CITY OF ALBUQUERQUE

March 24, 2015

RE: **Whataburger
Grading and Drainage Plan
Engineer's Stamp Date 2-18-2015 (File: K10-D001B)**

RE: **Whataburger
Grading Plan
Engineer's Stamp Date 2-18-2015 (File: K10-D001B)**

ENGINEER'S SEAL	WHATABURGER COORS AND CENTRAL	DRAWN BY B.J.F.
		STORMCHAMBER STORAGE SYSTEM	DATE 11/05/14
			2014075_GRB
			SHEET # C3
	RONALD R. BOHANNAN P.E. #7868	TIERRA WEST, LLC 5571 MIDWAY PARK PLACE NE ALBUQUERQUE, NM 87109 (505) 858-3100 www.tierrawestllc.com	JOB # 2014075

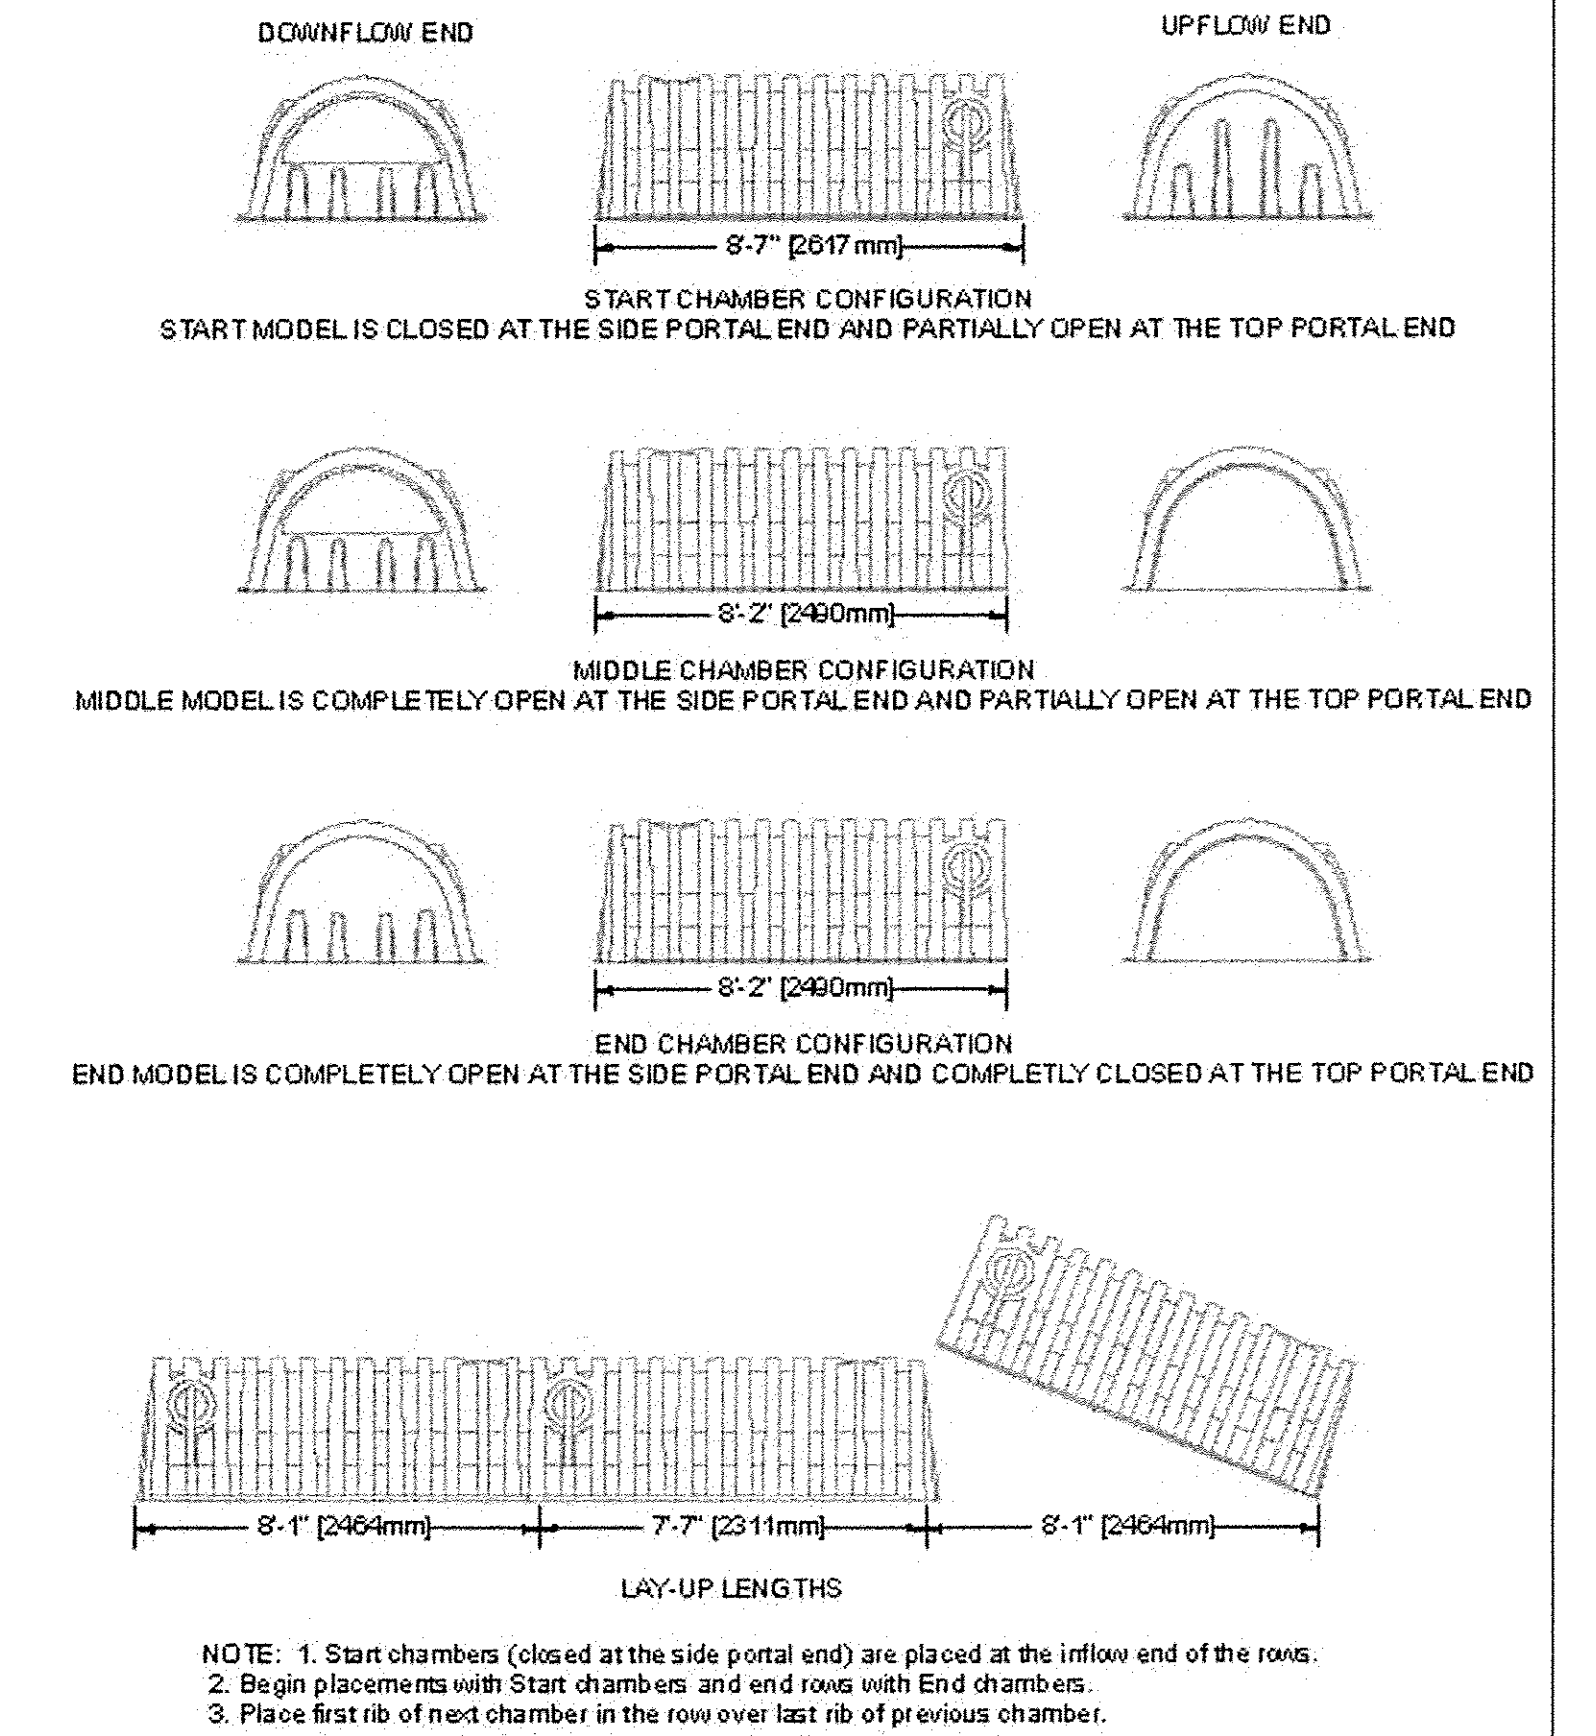
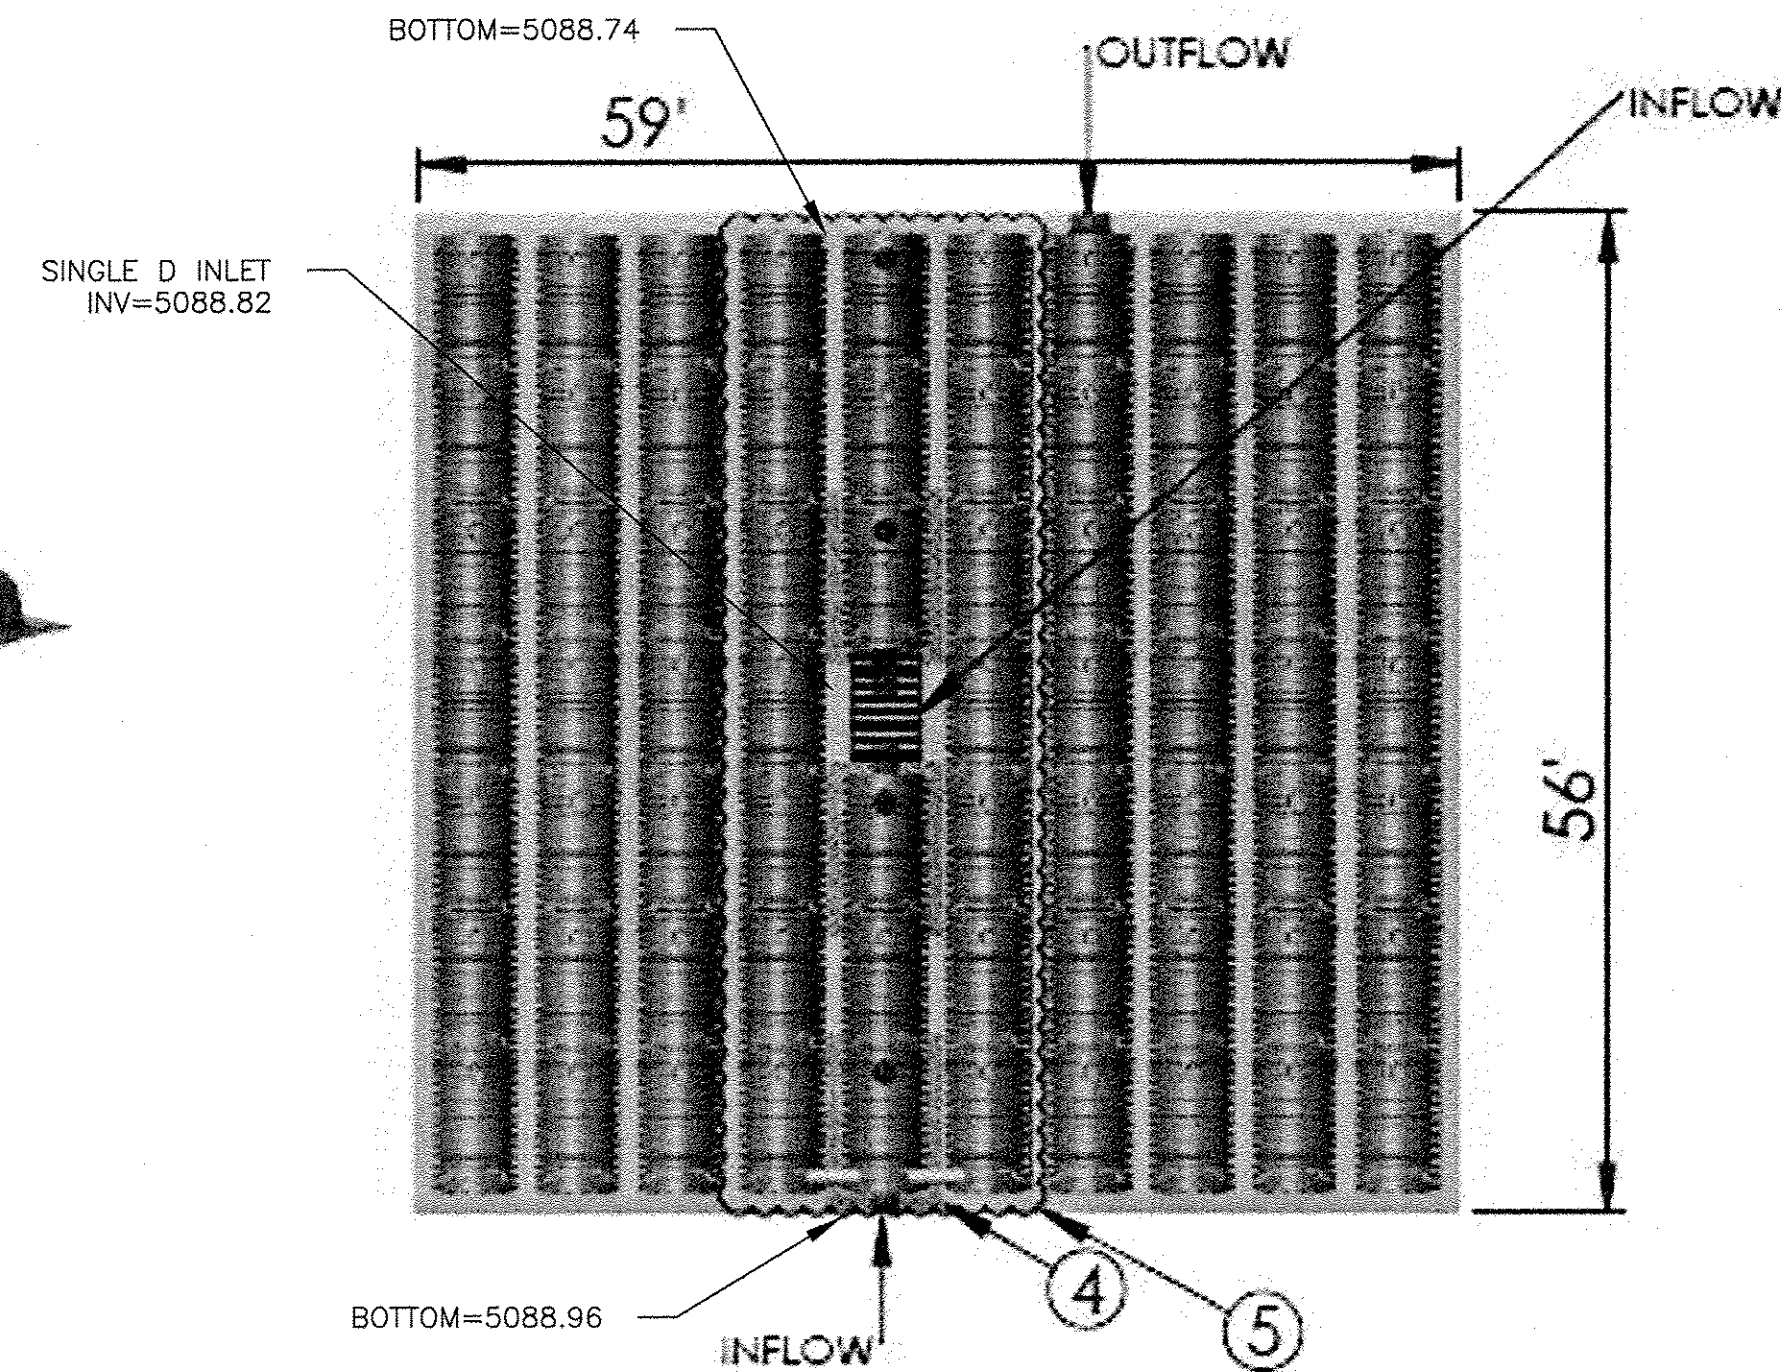
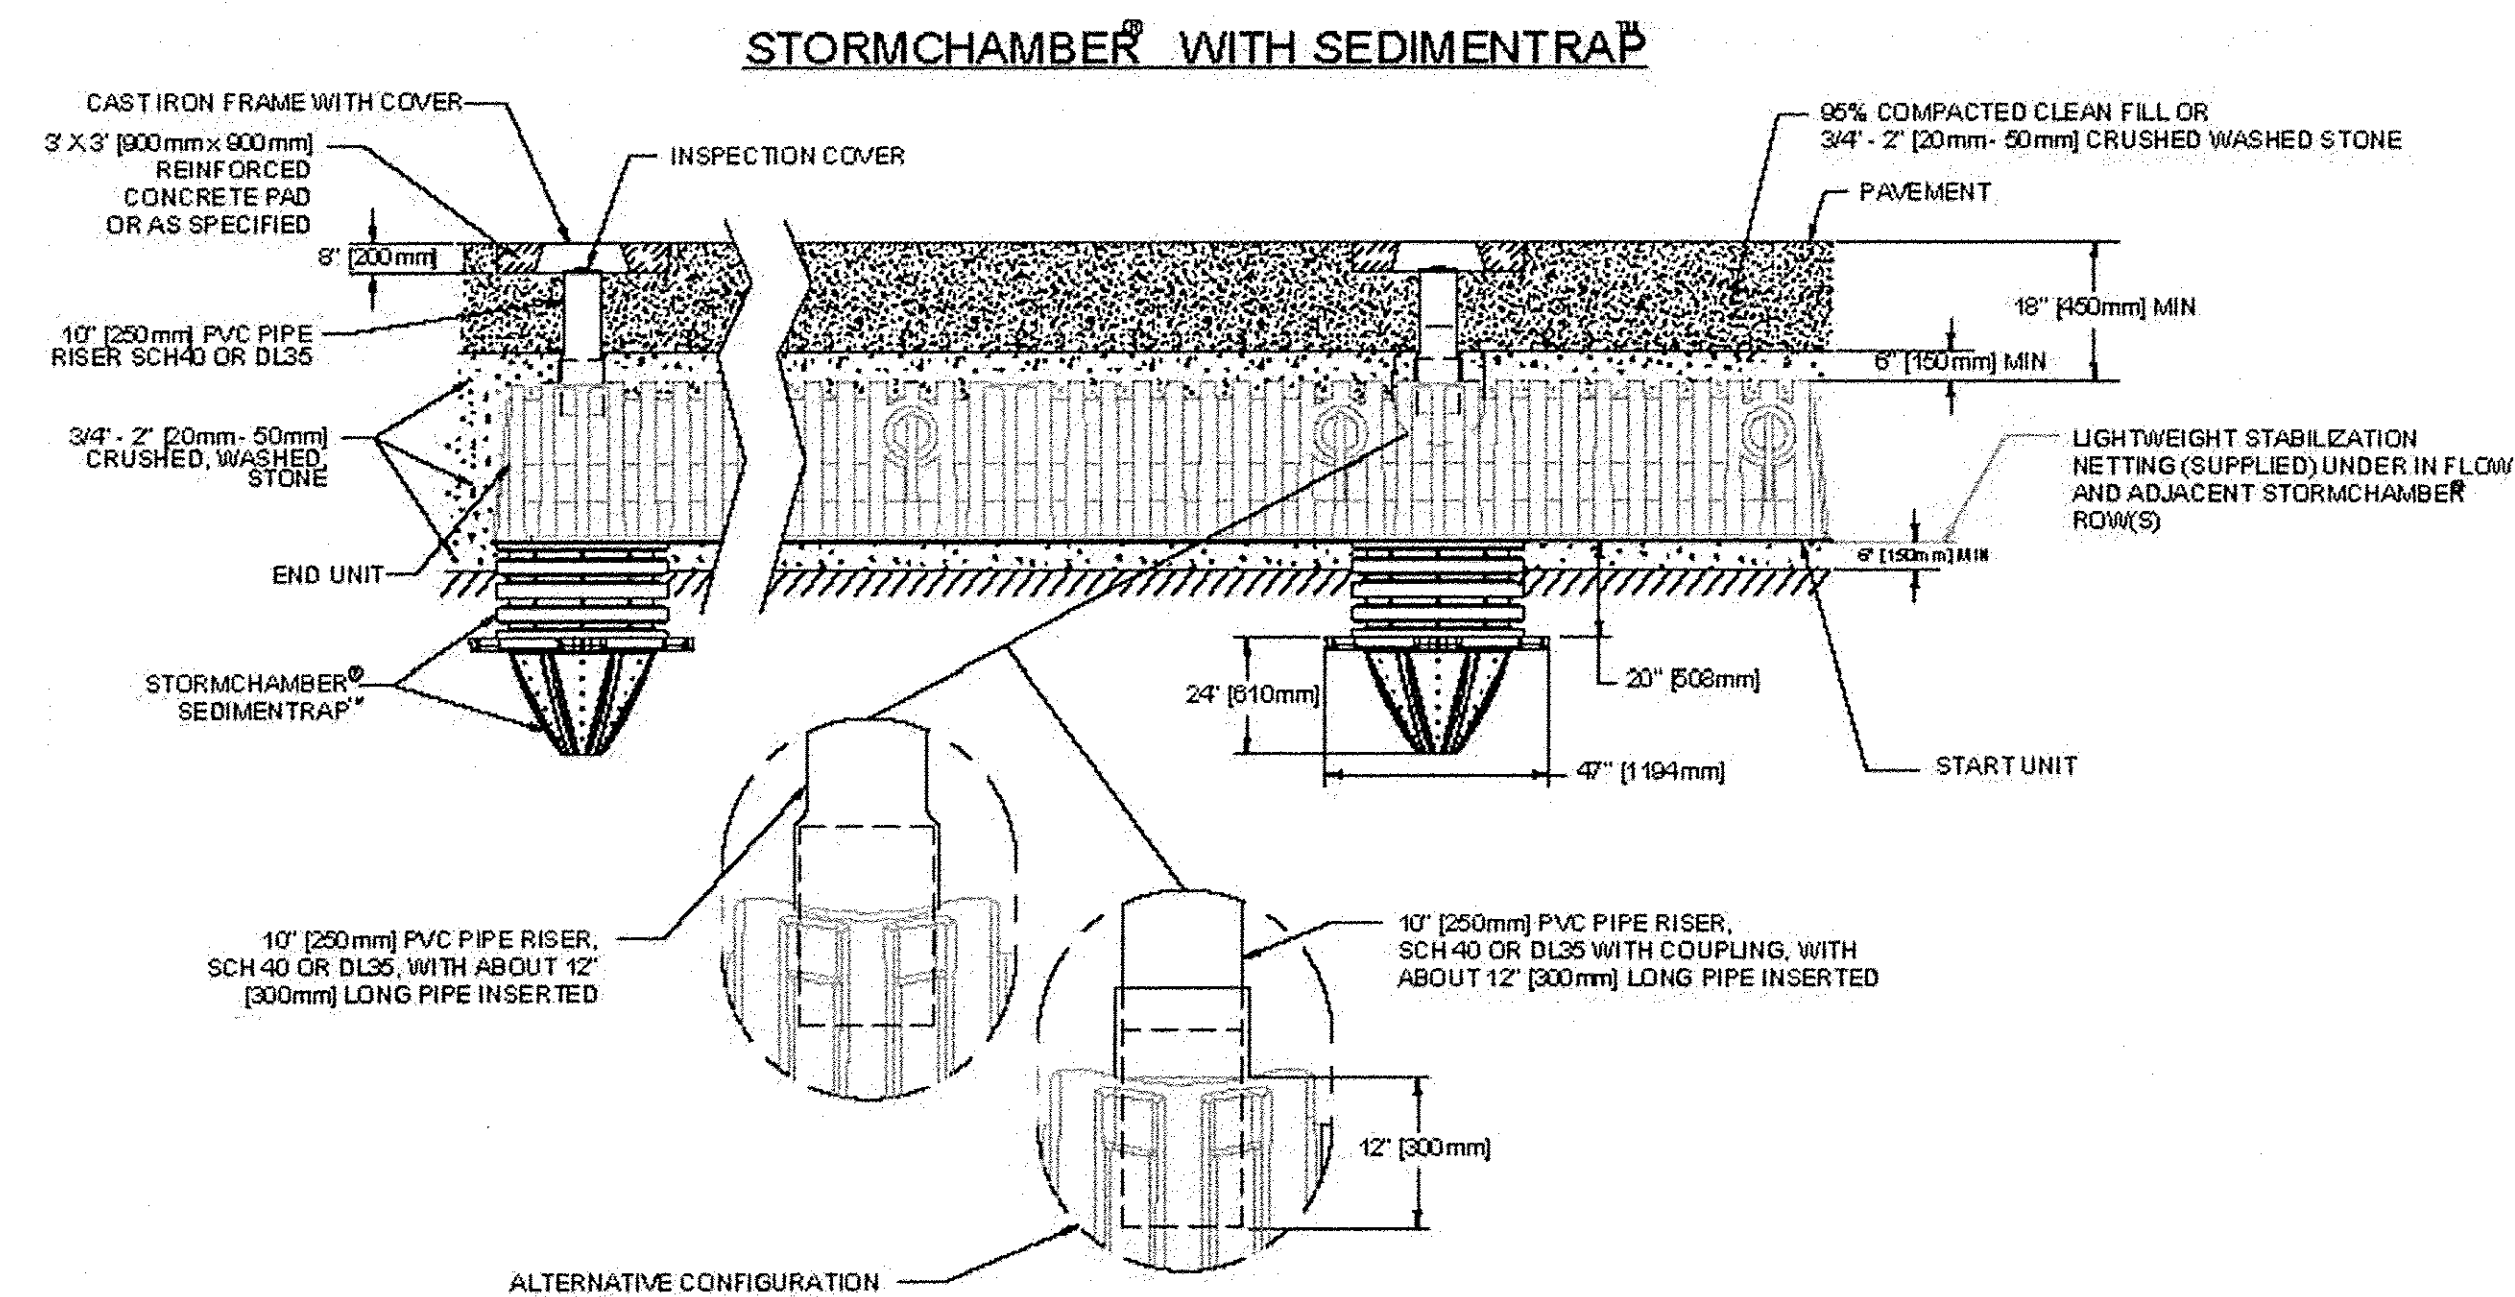
- 9) The number of chambers shown on the "Basin Map and Calculations" sheet is 75. This needs to be called out on the plan view detail on the "Stormchamber Storage System" sheet to make sure the right number of stormchambers will be installed. Also, please provide a legible table showing the layout dimensions for the stormchambers.
